**Application Ref: 14/00296/PREAPP**

**Location: Land At Kraft Foods Southam Road Banbury**

**Proposal: Proposed retail store for Waitrose.**

**Pre-Application Report**

PROPOSED PLANTING PLANS

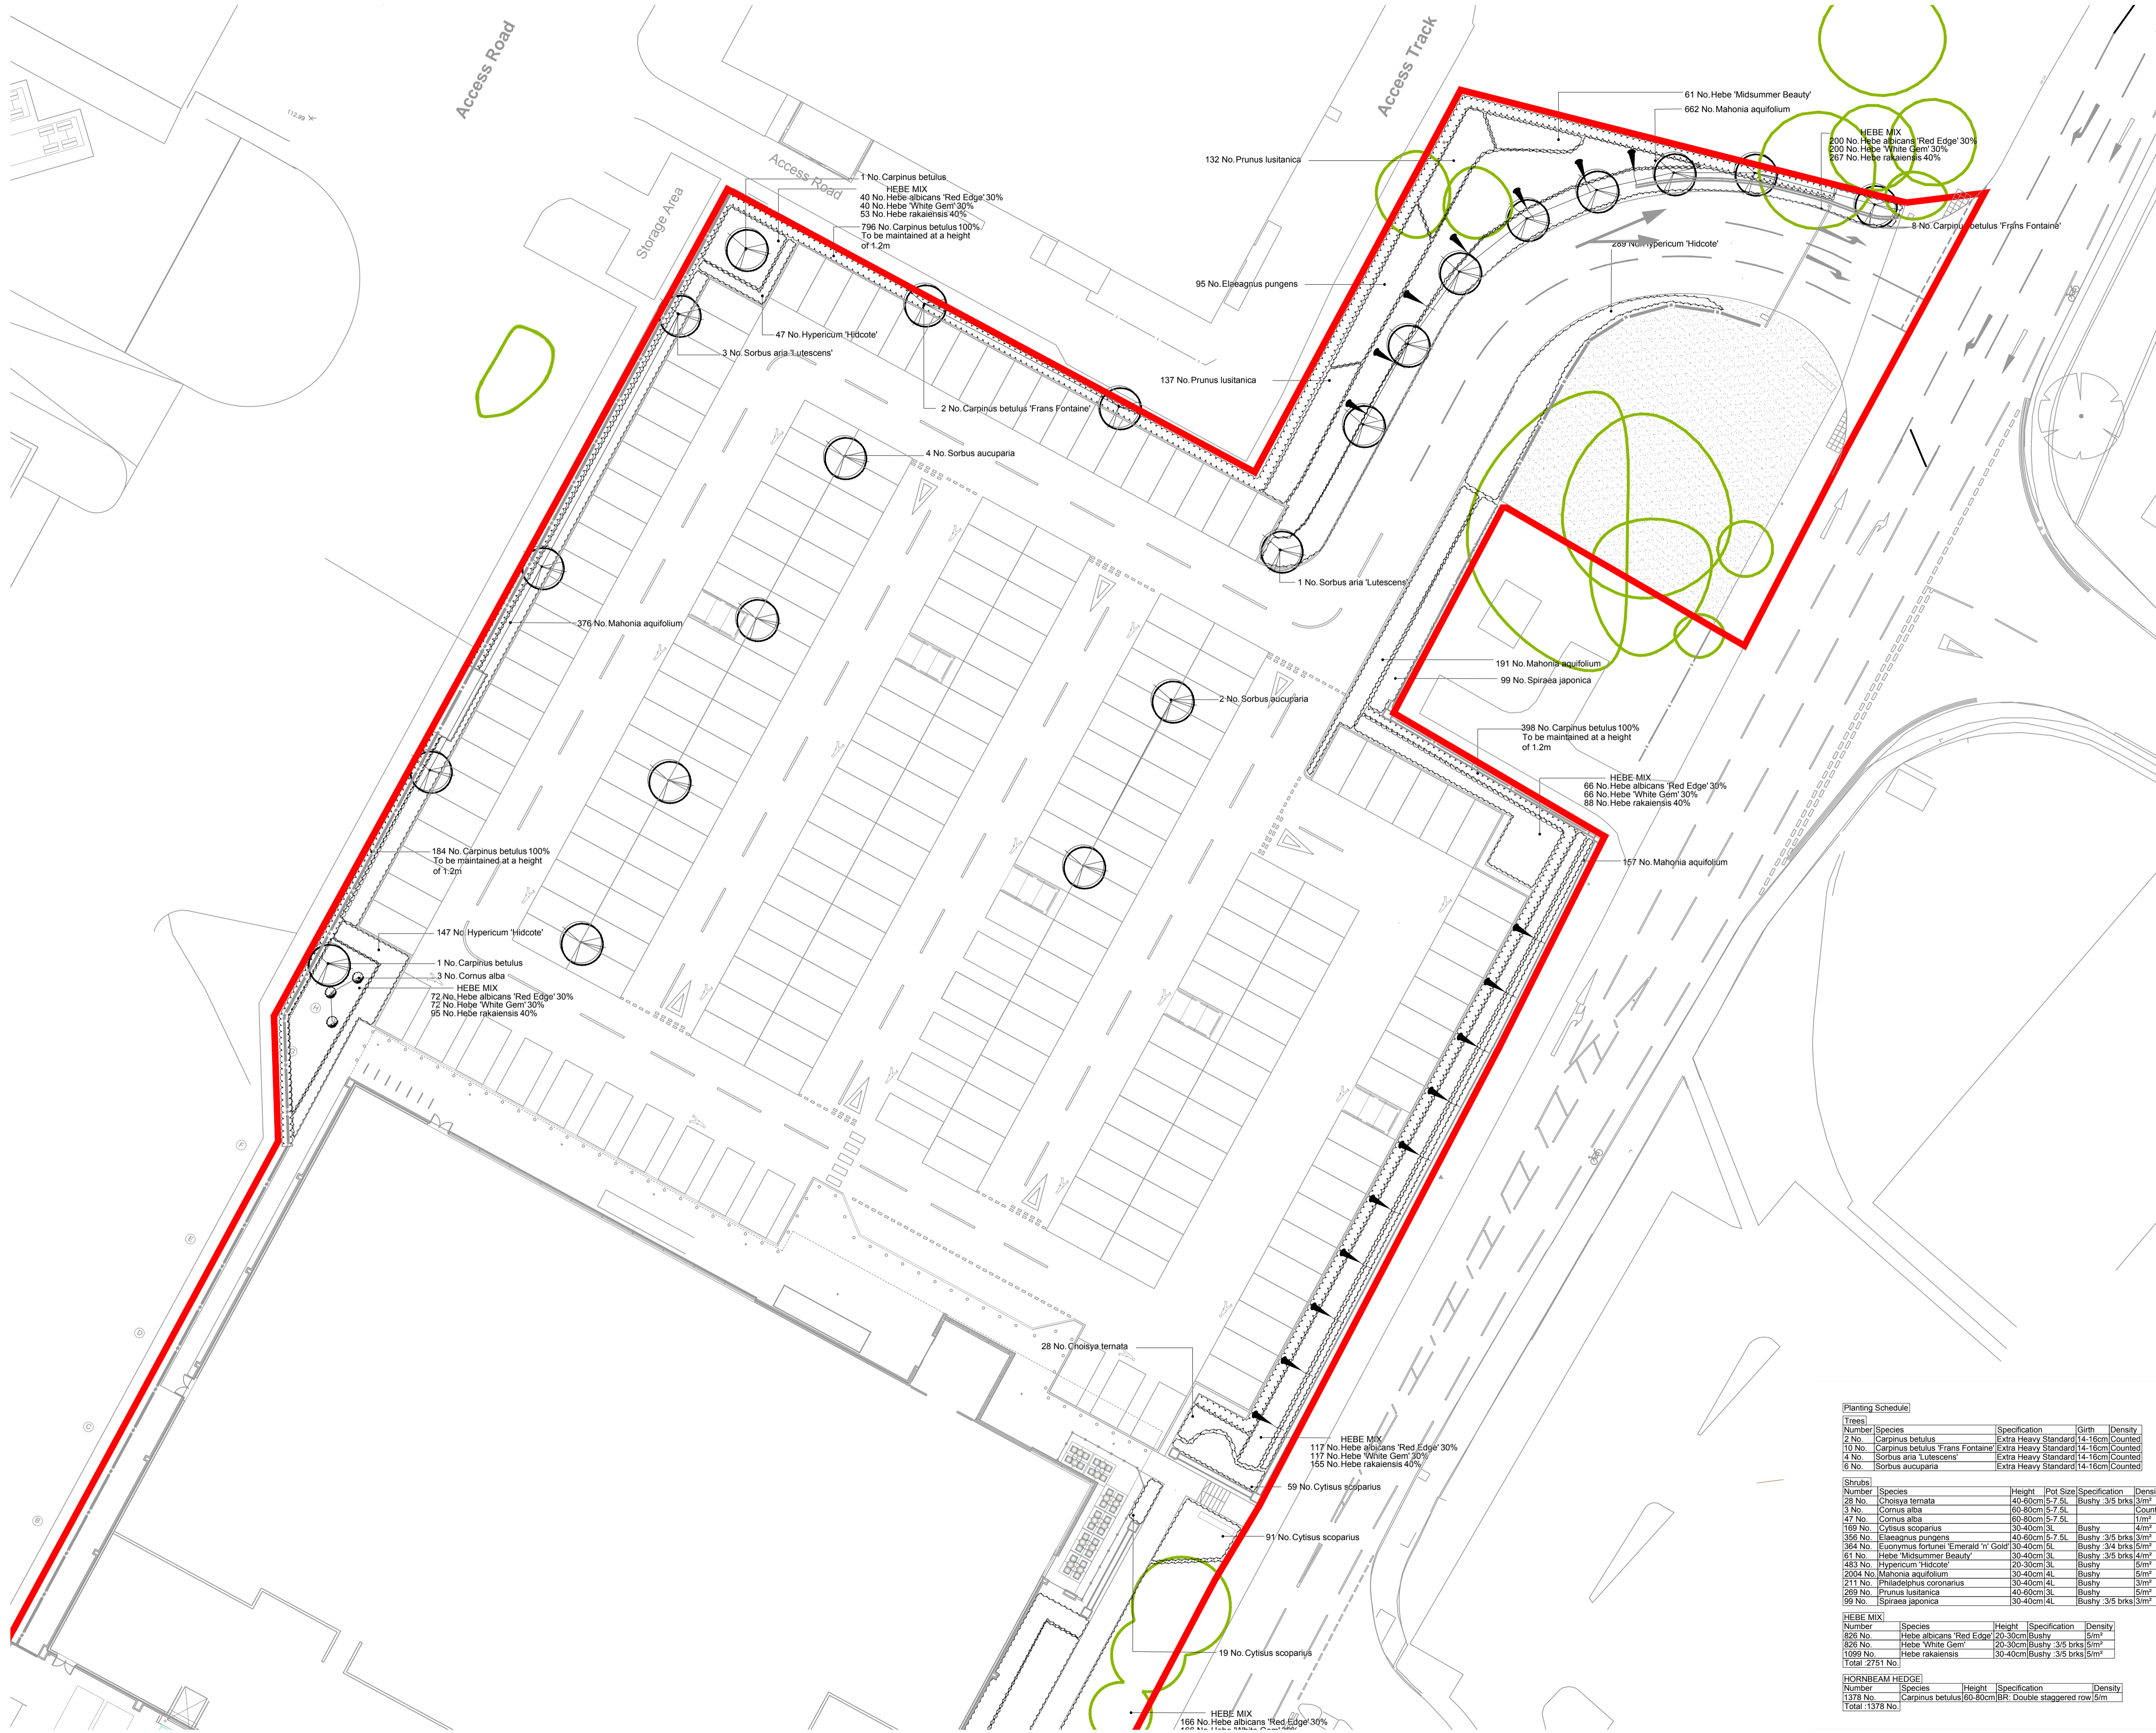
- The strong landscaped boundary with Southam Rd seems to have been thinned out on the layout plan. As the proposed building presents a blank side elevation to much of the Southam Rd frontage, this landscaping should be retained and enhanced. Thinning should only occur in the vicinity of the main access and at the north-east corner of the building where curtain-wall glazing is proposed and a pedestrian access to the store from the street;
- The main vehicular access should include a pedestrian footpath alongside the road and through the car park to the front door;
- The large car park would benefit from some trees and landscaping to help break up the space and complement the green edge to Southam Road;
- Covered cycle parking should be provided near to the store entrance for staff and customer use;
